Our ref: DOC19/922279

Senders ref: SSD 9343

Subject: New Request for Advice – Meadowbank Education and Employment Precinct Schools Project (SSD 9343) (City of Ryde) located at No. 2 Rhodes Street, Meadowbank

EES have reviewed the relevant documentation and provides the following comments:

Figure 9. Overland flooding under existing conditions for PMF event

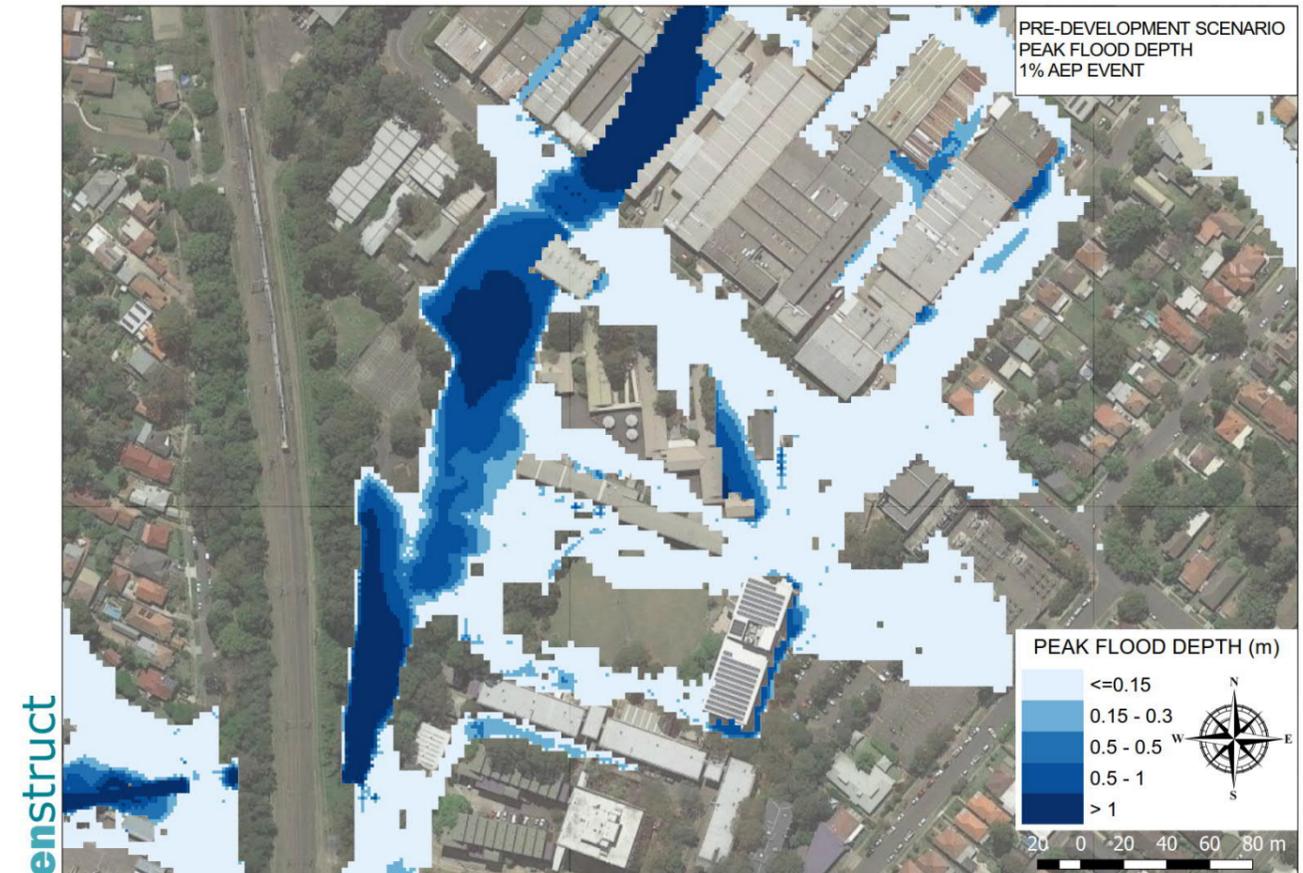
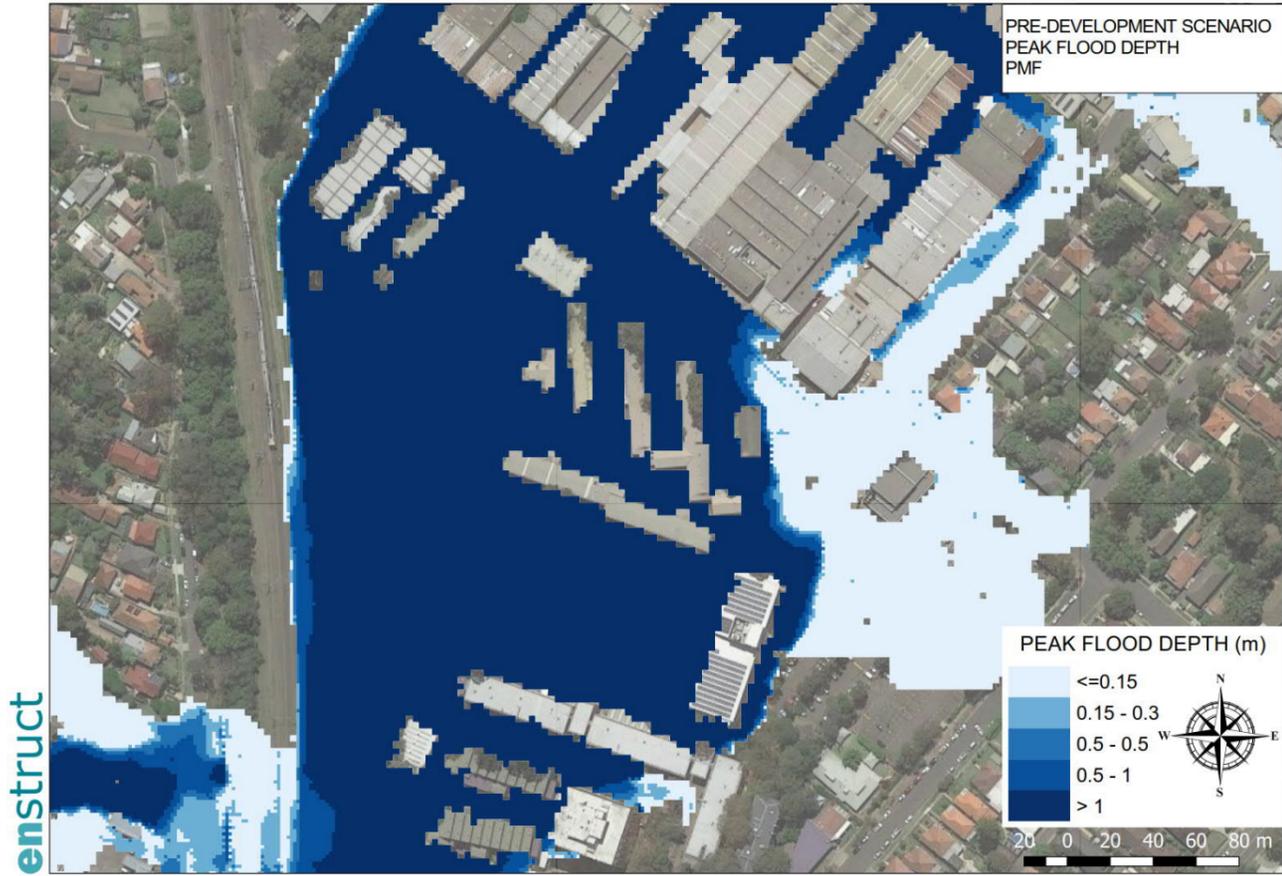
The site contains the main floodway of the Charity Creek catchment. The site is partially inundated in frequent flooding such as 20% AEP with flood depth up to 2m. The probable maximum flood (PMF) peak flood depth is illustrated in the Ryde Sub-Catchments Flood Study and Floodplain Risk Management Plan (SKM 2015). Sheet 2 of 2 of the Charity Creek Catchment section of the Report shows that, in such a rare event, the site is completely inundated with deep depth >2m and all access around the site is cut-off by flood depths greater than 2m. The catchment is susceptible to

flash flooding which is characterised by a short duration with no warning time and high flow velocity which can result in significant risk to life. The Civil Report has also outlined the site's existing flooding characteristics.

The proposed school can be classed as a special uses' facility due to the vulnerability of its users (i.e. the students). Therefore, it is prudent to adequately address flood risk for the full range of flood up to the PMF, particularly risk to life. The Civil Report outlines the flood characteristics; however, it does not address the associated flood risk due to the exposure to flooding with these characteristics.

From a floodplain risk perspective, the flood assessment should not be limited to addressing existing flood behaviour, impacts of proposed development on existing condition and flood planning level. It should also address the following floodplain risk management aspects:

- whether the development will expose its potential users to an unacceptable level of flood risk due to exposure to flooding for the full range of flood;
- whether the development will increase the requirement for emergency services to plan and implement flood emergency management measures for future users of the development, particularly if the development is of vulnerable nature, due to exposure to flooding for the full range of flood.

The above floodplain risk management aspects are essential to be addressed in this stage of planning to guide decision-making. Moreover, this information should also be utilised to prepare a detailed floodplain risk management assessment that addresses emergency response measures in consultation with the State Emergency Service (SES) to ensure risk to life is adequately addressed.
